Advice on Environmental Impact Statement – State Significant Development

Proposal: Leichhardt Oval Refurbishment

Major Project reference: SSD-85149458

Figure 1: Location of study area

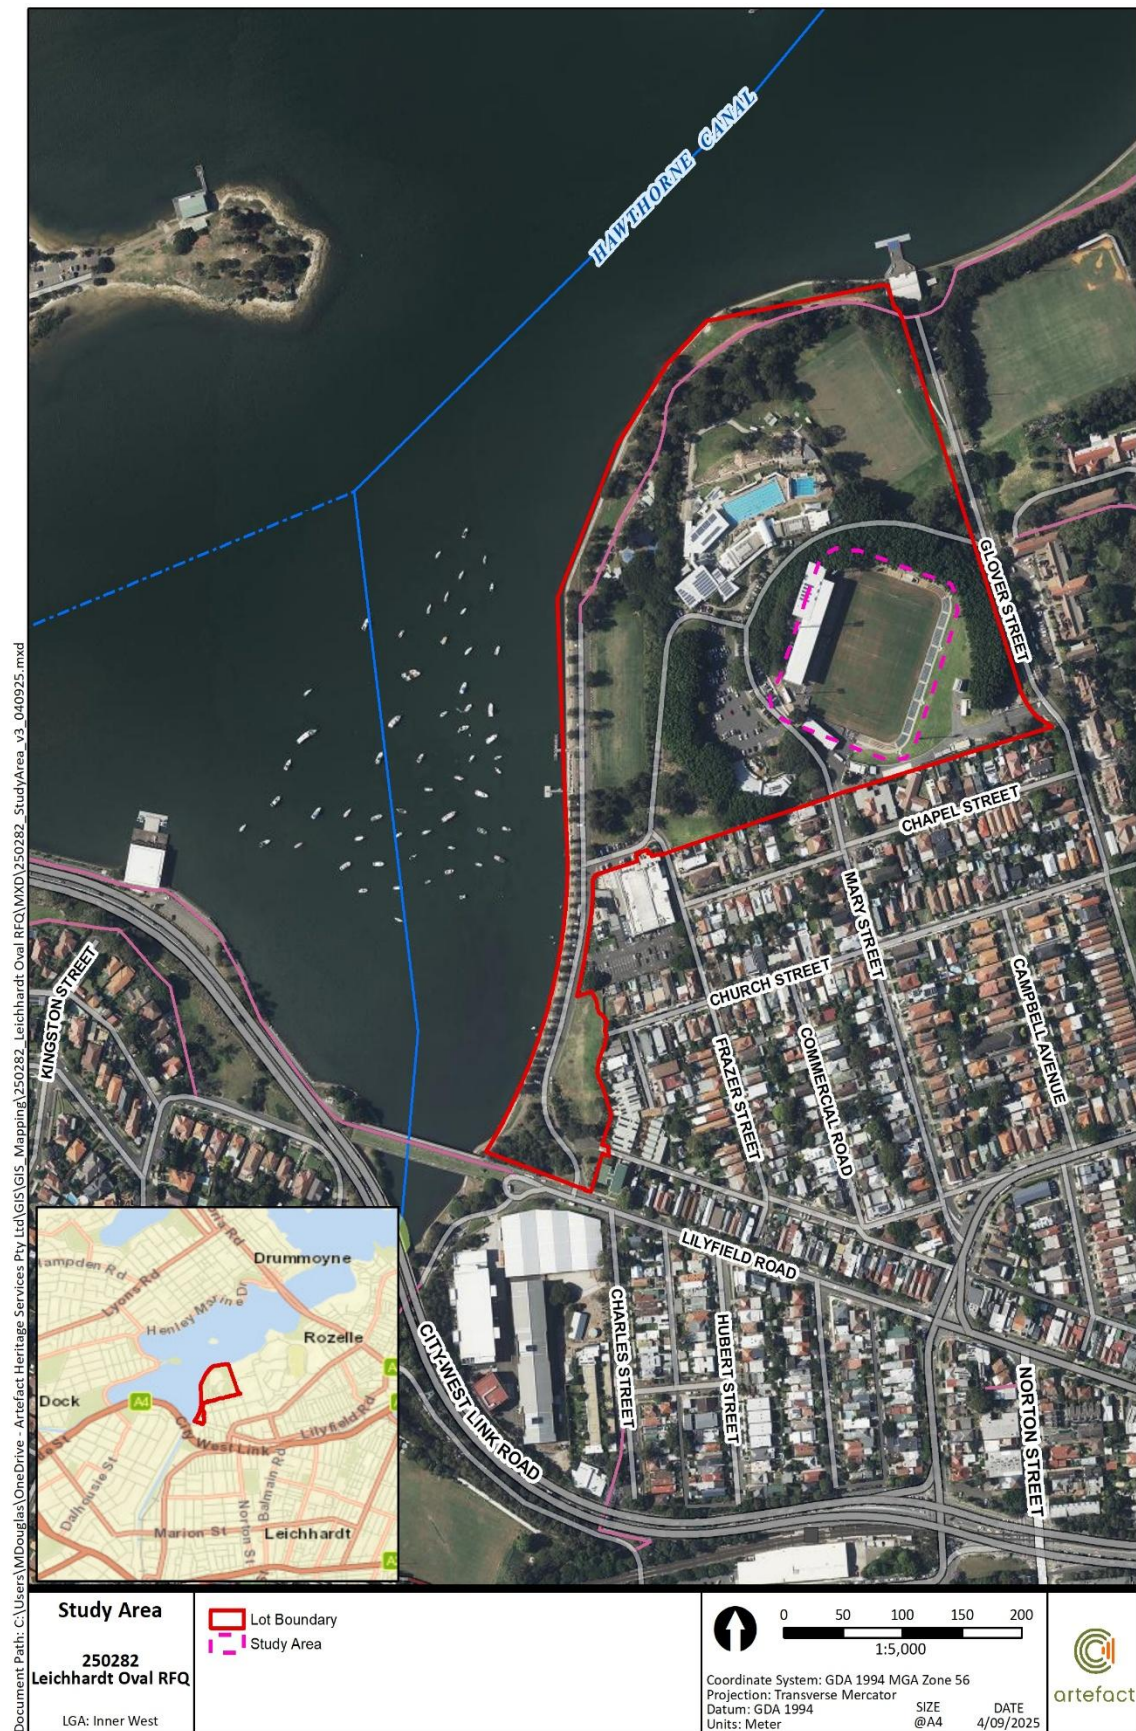
1. Mapping undertaken for the assessment shows both the lot boundary and a smaller study area, which differs from the extent of the site shown in the architectural and landscape plans in appendices E and M of the Environmental Impact Statement. Please review and update the assessment where necessary to demonstrate that the study area encompasses all works proposed as a part of the SSD application, and that these works have been appropriately assessed.
